KITTITAS COUNTY

MEMORANDUM

TO: All Staff
FROM: Public Works Plan Review Team
DATE: December 3, 2024
SUBJECT: BL-24-00024 Maxfield

RECORD OF SURVEY  
A PORTION OF THE NW 1/4 OF THE NW 1/4 OF SECTION 9,  
TOWNSHIP 21 N., RANGE 14 E., W.M., KITTITAS COUNTY, WASHINGTON

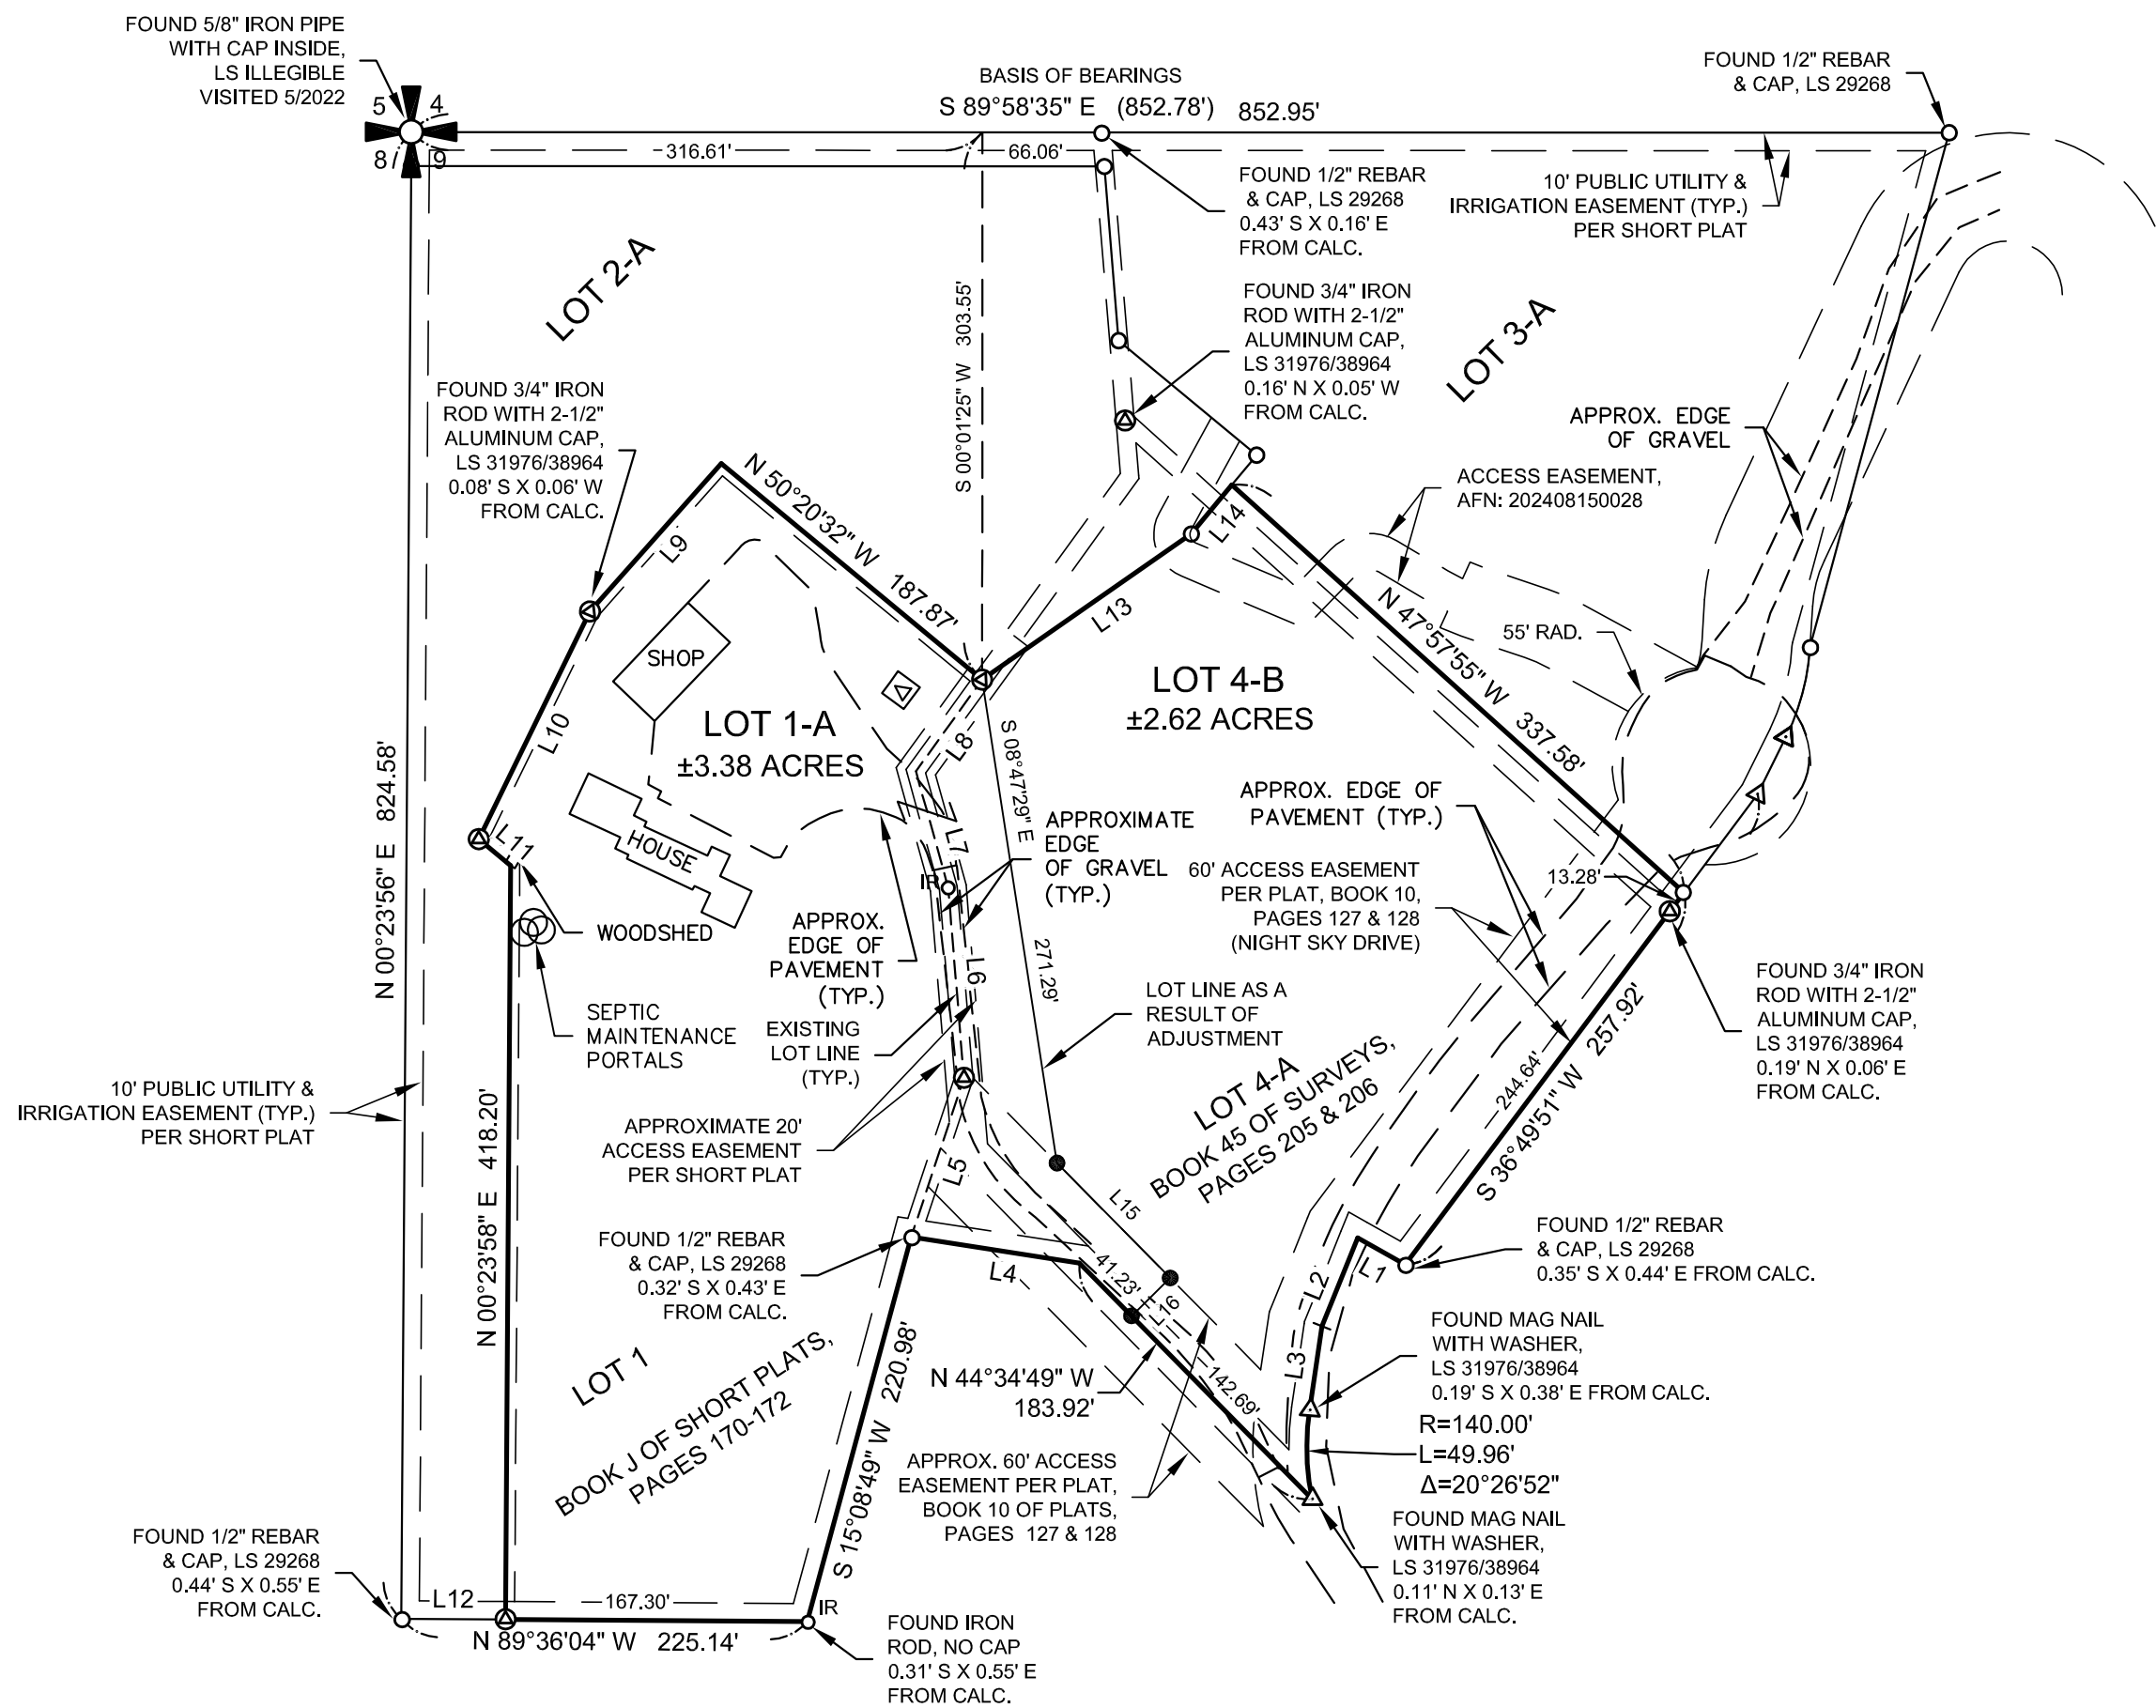
SURVEY	<p>The submitted map is suitable for prelim BLA review. The following comments are in regards to the final survey.</p> <ol style="list-style-type: none">1. At a minimum, the new division line between parcel should be staked in the field and set corners shown on the face of the map.2. In the proposed legal descriptions there is a typo, referencing Lot "3-A" rather than Lot "2-A" (4 occurrences). <p>Of Note</p> <p>Multiple found corners are shown with coordinate differences between found and calculated positions. While a surveyor would naturally presume that these values are from the calc position to the found corner, a general member of the public may think the inverse. Applicant MAY want to consider adding language such as "0.1'Nx0.2'E of calc" or "0.1'Nx0.2'E from calc" to clarify.</p>
